Approval of details reserved by condition imposed under ref AW/279/18/RES relating to Condition Nos 5-site set up, 6-vehicle wheel-cleaning, 7- schedule of materials & finishes, 8-landscaping, 9-screen walls/fences, 10-bin enclosure, 12-cycle parking & 13-electric vehicle charging points.

261 Aldwick Road Aldwick PO21 3QU

Condition Number 10

Arun District Council have decided to **APPROVE details reserved by this condition**

19003-cycle store

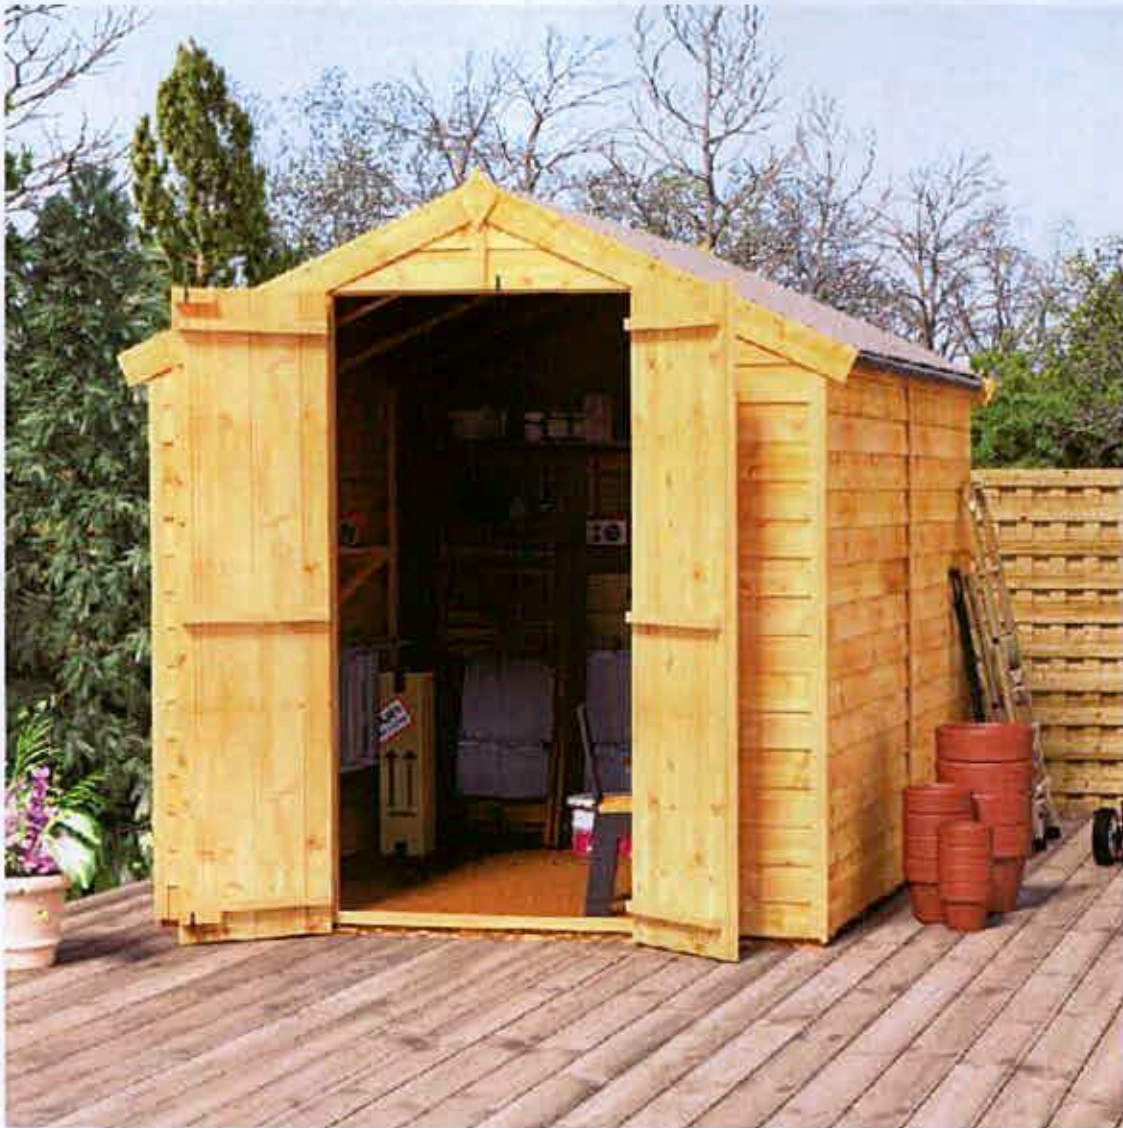
The submitted details in respect of the storage of waste and recycling namely the location of the bin stores (elevations provided on drawing 19003-201 "Bin/Cycle Stores") in the positions shown on the Site Plan drawing 19003-200 Rev B are considered to provide an acceptable scheme and satisfy the requirements of the condition. The Site Plan drawing also shows an acceptable position for the bin collection point.
